STATE OF WASHINGTON
DEPARTMENT OF ECOLOGY

November 1, 2010

Re: RZ-09-00001

Thank you for the opportunity to comment during the optional determination of nonsignificance process for the Number 5 Canyon Planned Unit Development, proposed by Central Cascades Land Company, Inc. We have reviewed the documents and have the following comments.

**NO. 5 CANYON  
PLANNED UNIT DEVELOPMENT - PHASE I  
A PORTION OF SECTION 21, T.20N., R.15E., W.M.  
KITITAS COUNTY, STATE OF WASHINGTON**

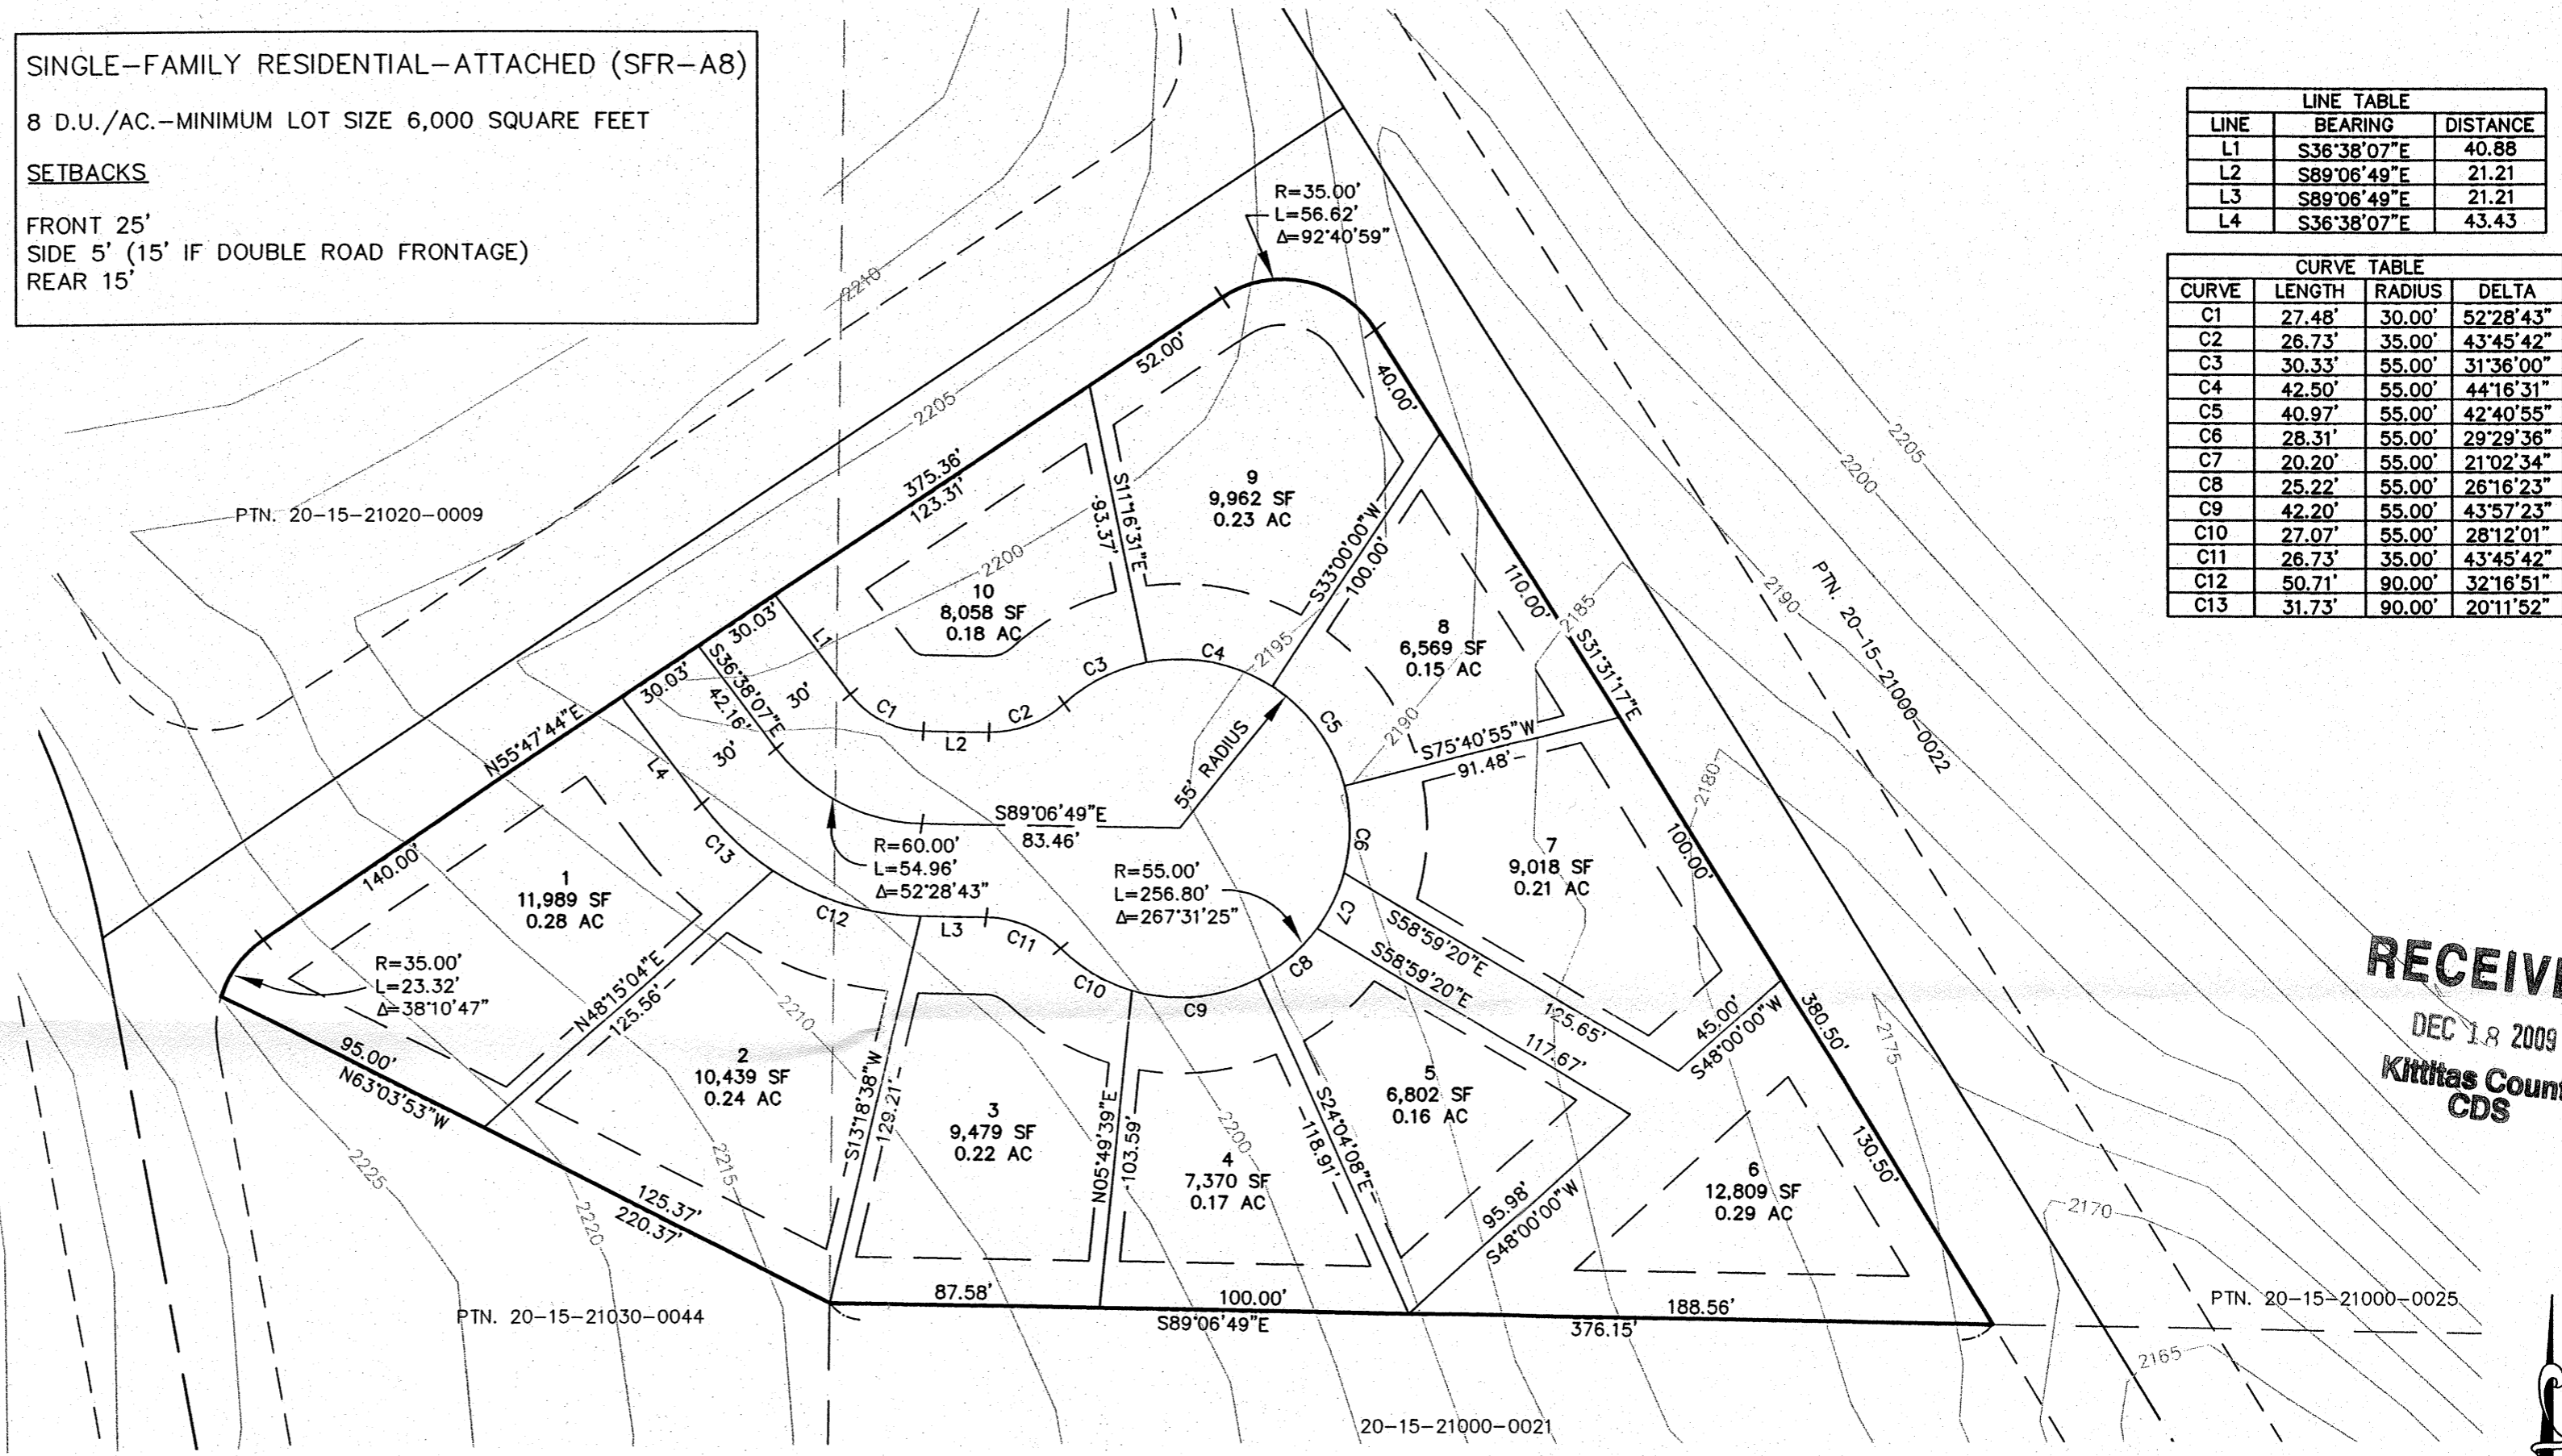
The configuration for residential build-out of Number 5 Canyon Phase 1 PUD is superimposed on a contour map which shows a swale running right down the center of the proposed cul-de-sac. Will the access road to the cul-de-sac intercept this water, and where will the water be routed? Will the opportunity to provide additional public SEPA review of each build-out phase with respect to stormwater and other issues occur in the future? If not, then these issues should be addressed during the current SEPA review period.
